Solberg Pit - El Paso County Land Use Application Curtis Road & Garrett Road Traffic Impact Analysis

August 2023

Holcim WCR, Inc.

Y2K Engineering, LLC.

Figure 4: Site Plan

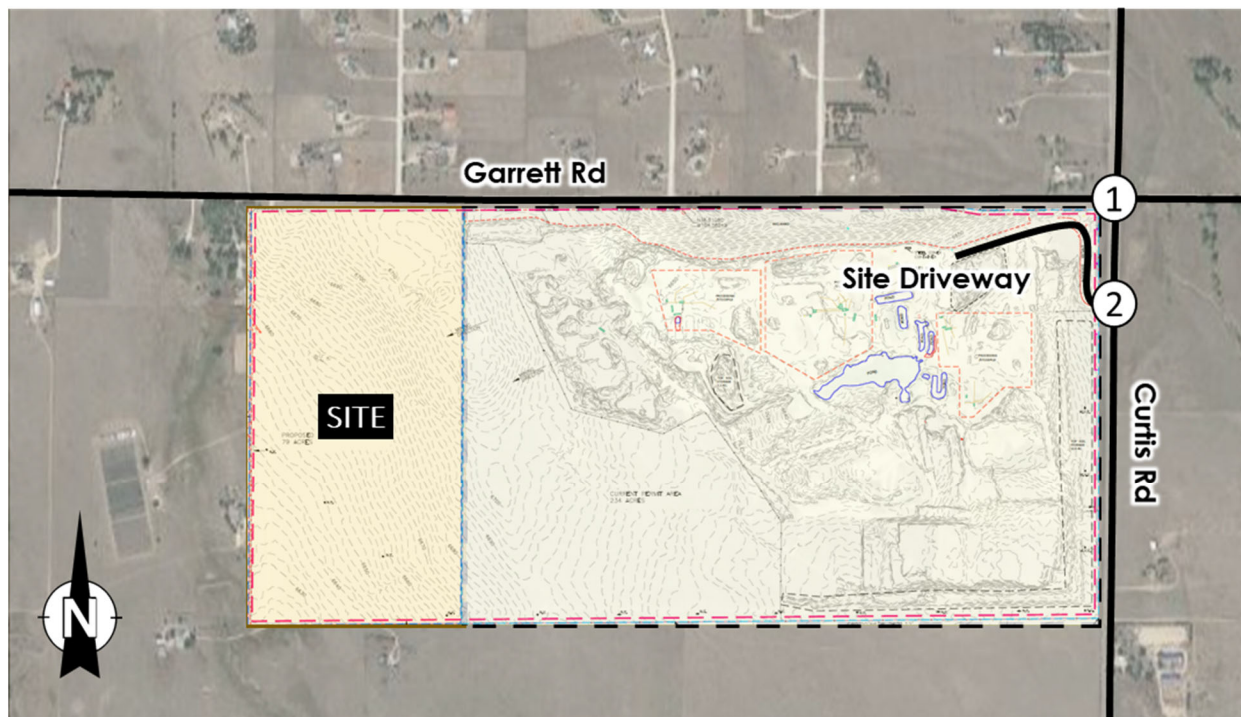
should this be west on Garrett?

Indicate the Haul vehicles destination from Garrett Rd. I assume that it is to Hwy 24 as opposed to another County Rd. Please state it in the report and clearly state that this is the intended Haul route

Also please indicate if all vehicles (haul vehicles & passenger car/truck) will utilize the same haul route.
